July 25, 2025

**Re: Hope Charter School at 5310 Sequoia Rd NW
Erosion and Sediment Control Plan
Engineer's Stamp Date - missing - G11E048 (SWQ-2025-00041)**

James D. Hughes, P.E., CPESC
Principal Engineer, Planning Dept.
Development and Review Services

EROSION CONTROL PLAN

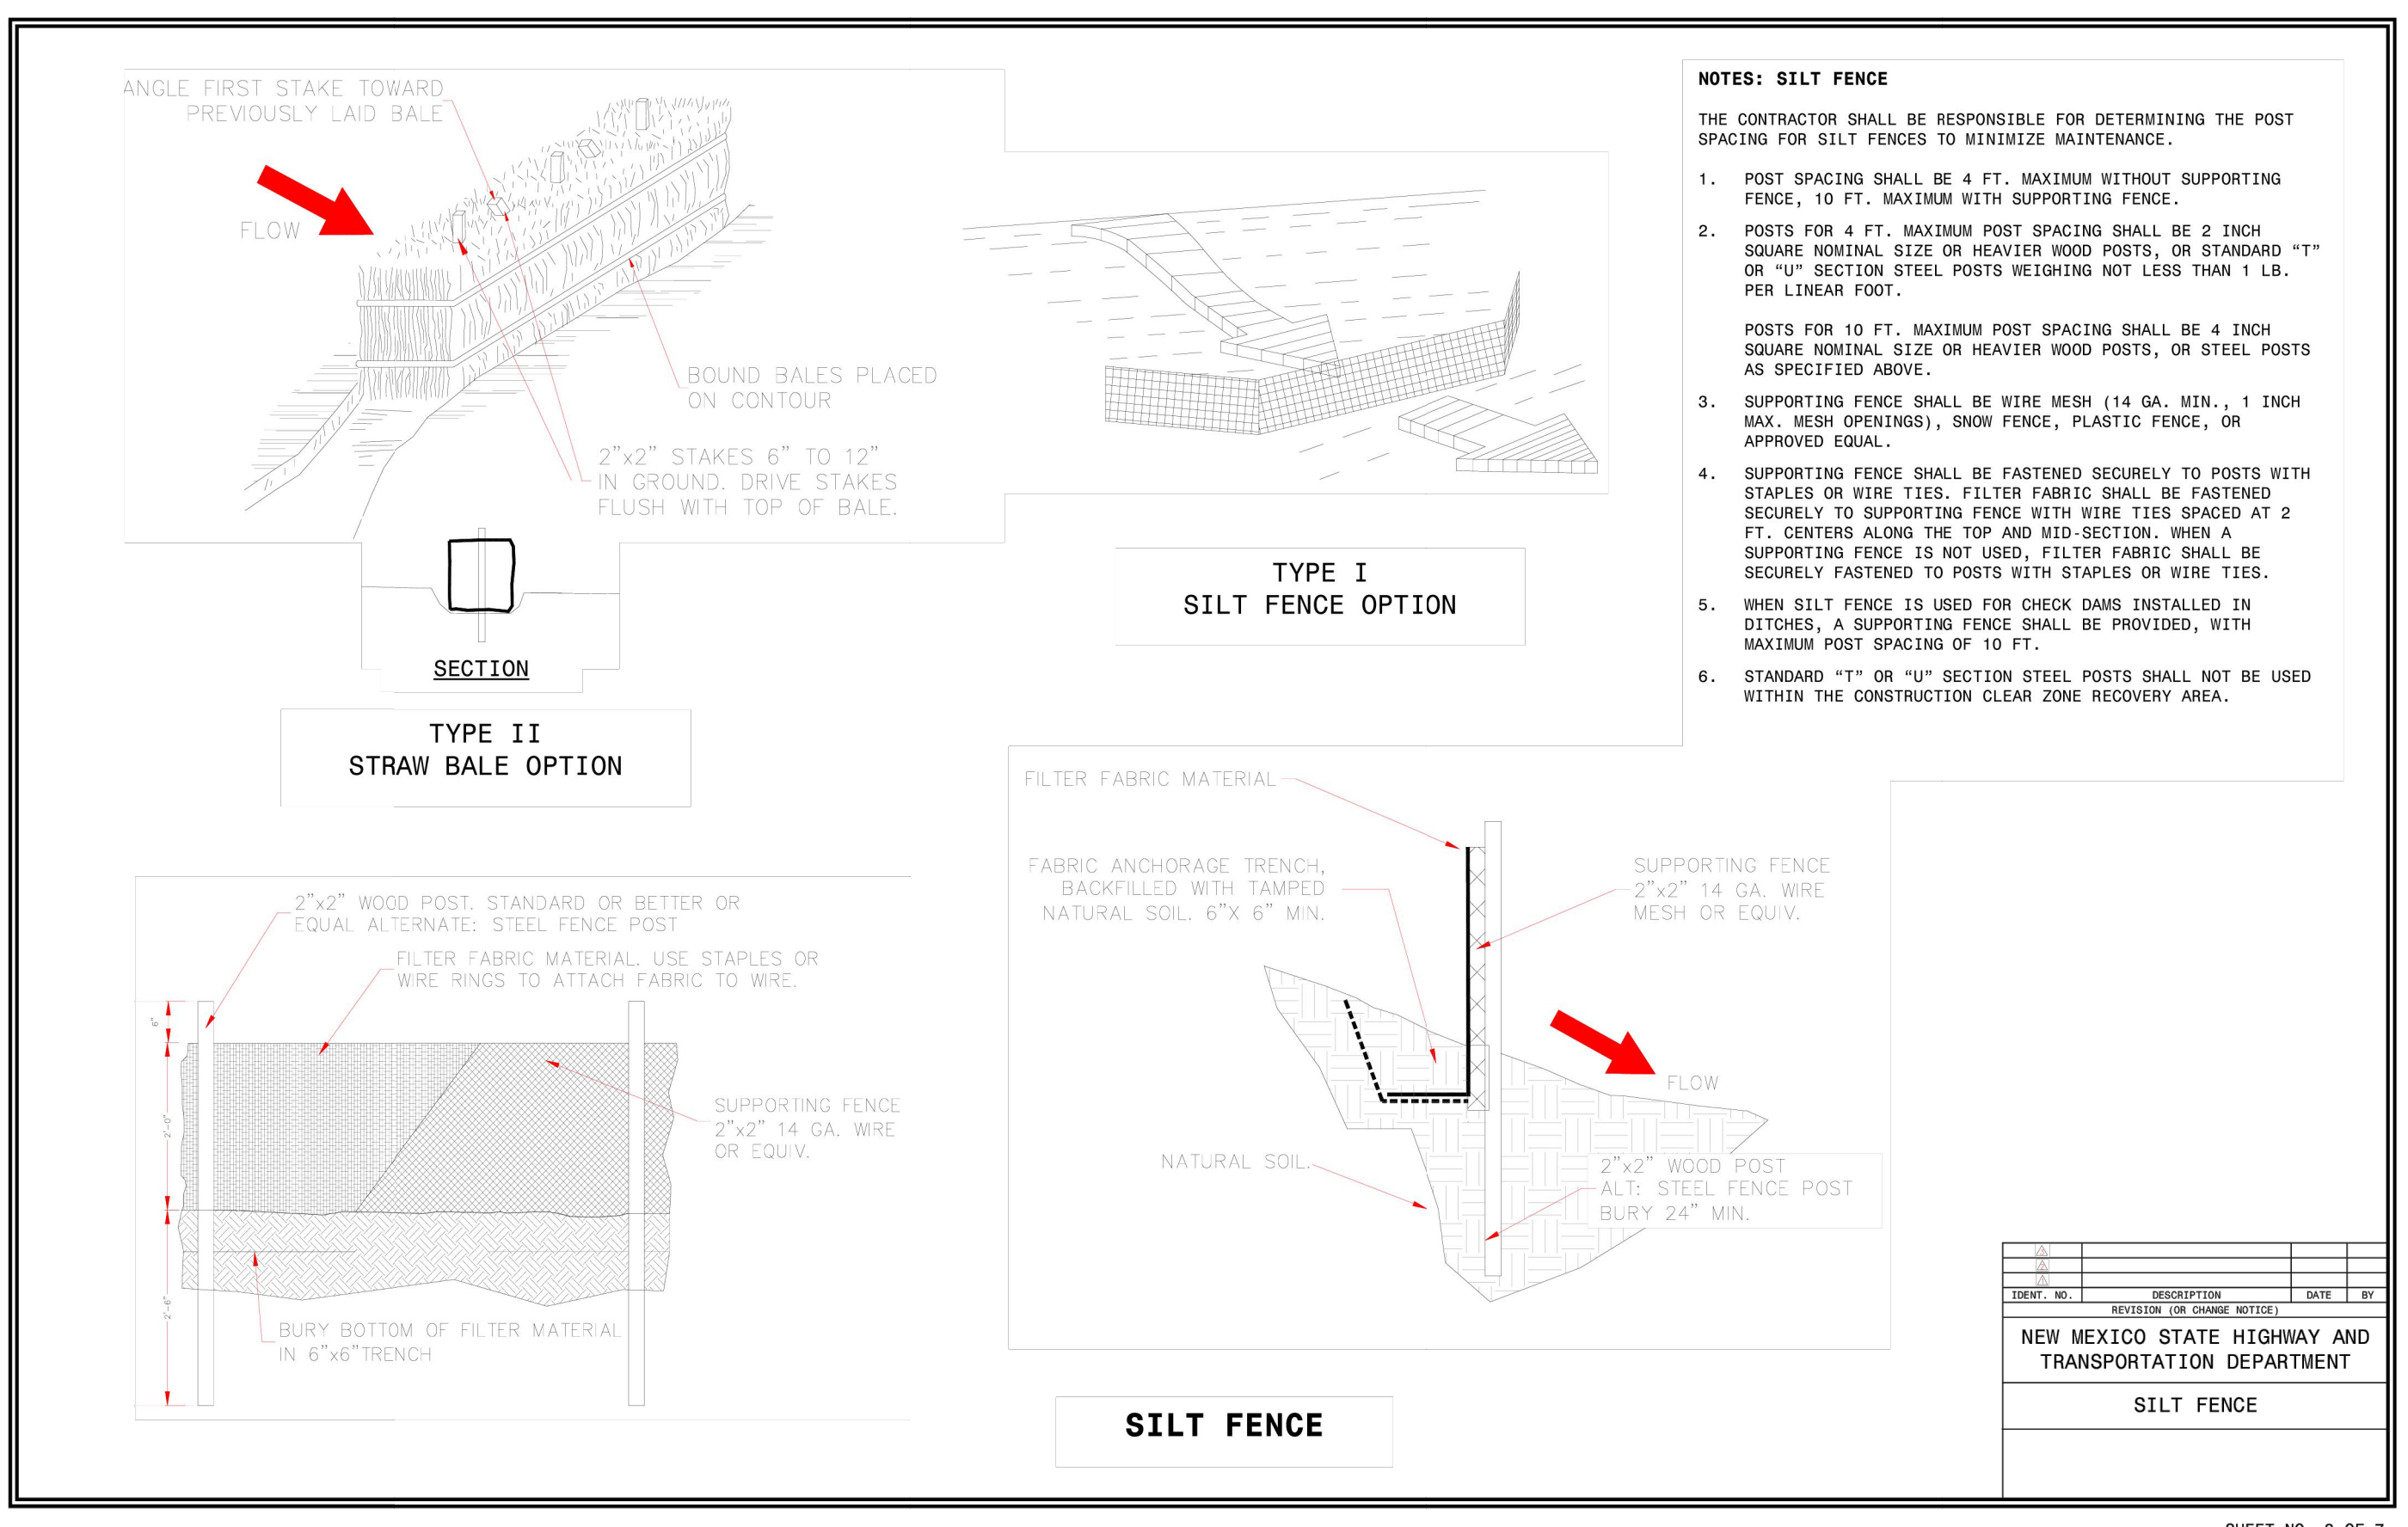
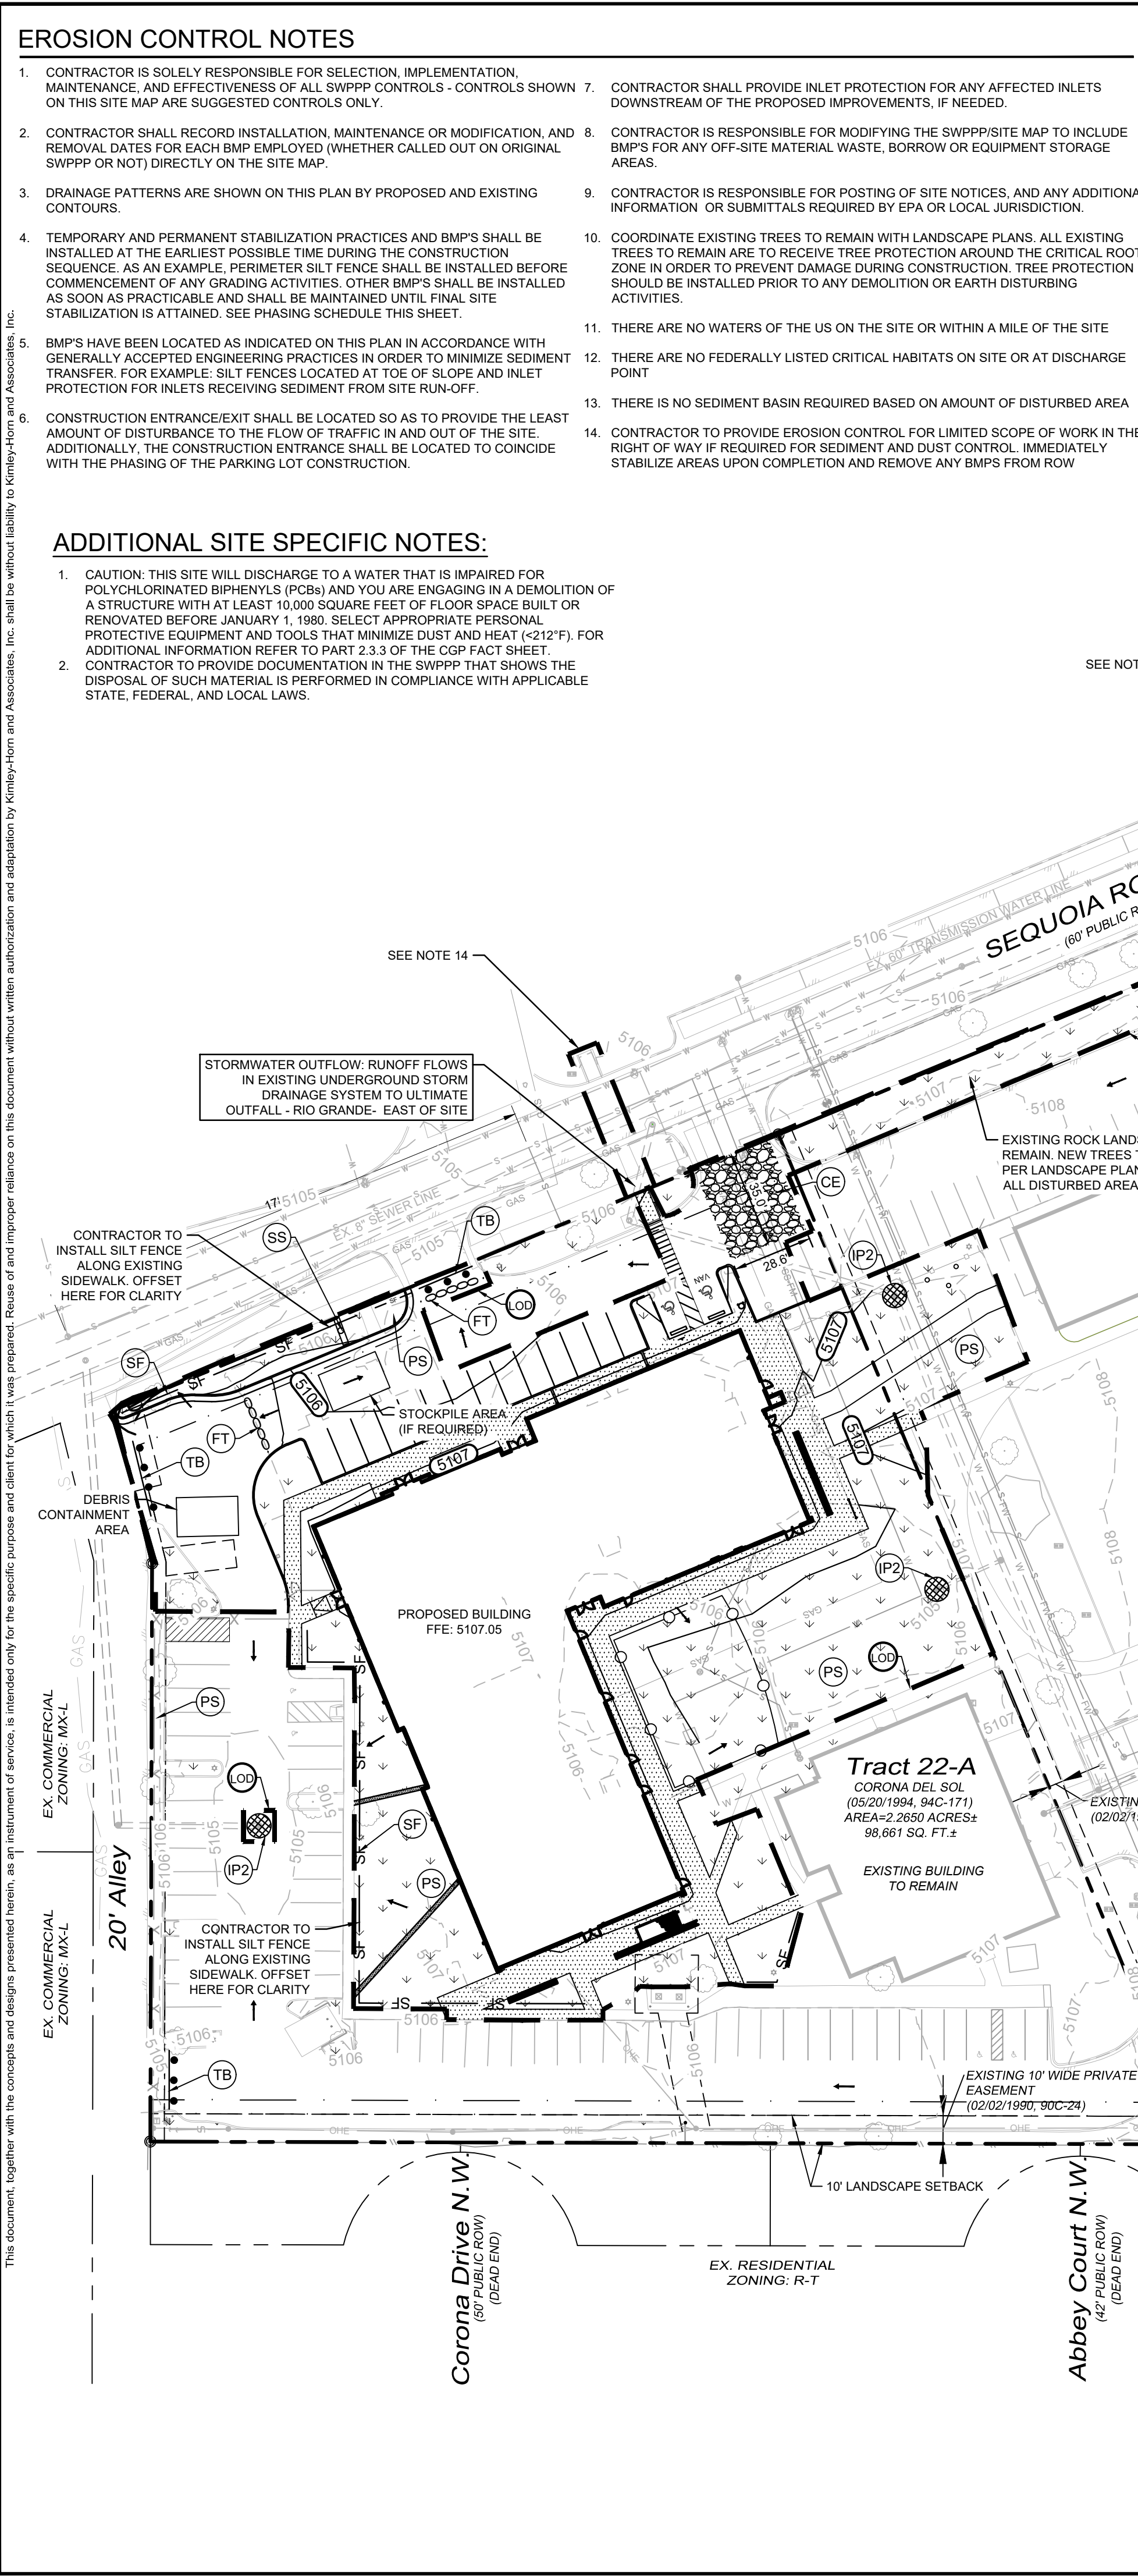
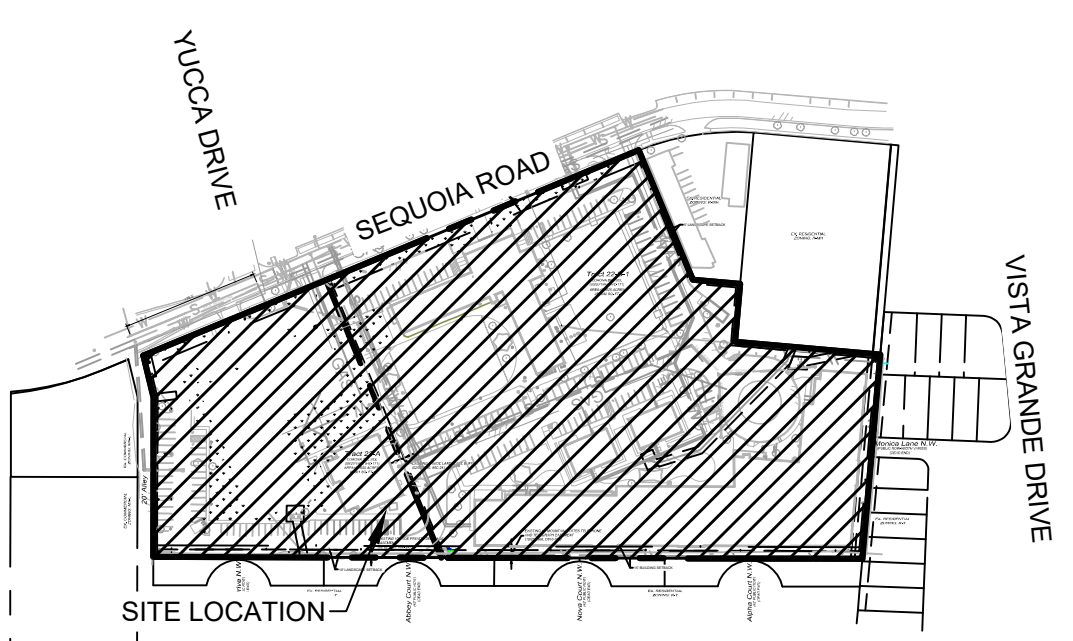
1. The ESC Plan was missing. Instead of the ESC Plan, the SWPPP was uploaded. You need to remove any unnecessary information and upload only the sheets of the ESC Plan according to the ESC Plan Checklist (attached), formatted on 22" x 34" sheets following the drafting standards, with all sheets certified by a PE or a CPESC. The ESC Plan should stand alone as a separate document from the other construction plans for the project.

5. City standard notes attached must be included on the ESC Plan. Add additional notes and ESC BMPs for demolition of the west building to comply with CGP 3.2.

- a. Note - *"Caution: this site will discharge to a water that is impaired for polychlorinated biphenyls (PCBs), and you are engaging in demolition of a structure with at least 10,000 square feet of floor space built or renovated before January 1, 1980. Select appropriate personal protective equipment and tools that minimize dust and heat (<212°F). For additional information, refer to Part 2.3.3 of the CGP Fact Sheet."*

- b. Note - *“Provide documentation in the SWPPP that shows the disposal of such materials is performed in compliance with applicable State, Federal, and local laws.”*
- c. Identify controls on the ESC Plan to minimize the exposure of PCB-containing building materials, including paint, caulk, and pre-1980 fluorescent lighting fixtures, to precipitation and stormwater. Separate work areas from non-work areas and construct a containment area so that all dust or debris generated by the work remains within the protected area.
- 6. Update the engineer’s stamp date on all sheets each time a change is made to any of the sheets. All ESC Plans must be prepared in accordance with good engineering practices by qualified professionals (e.g., CPESC-certified engineers with appropriate training) specializing in erosion control, as per CGP 9.6.1.c.iii., and should be numbered sequentially.
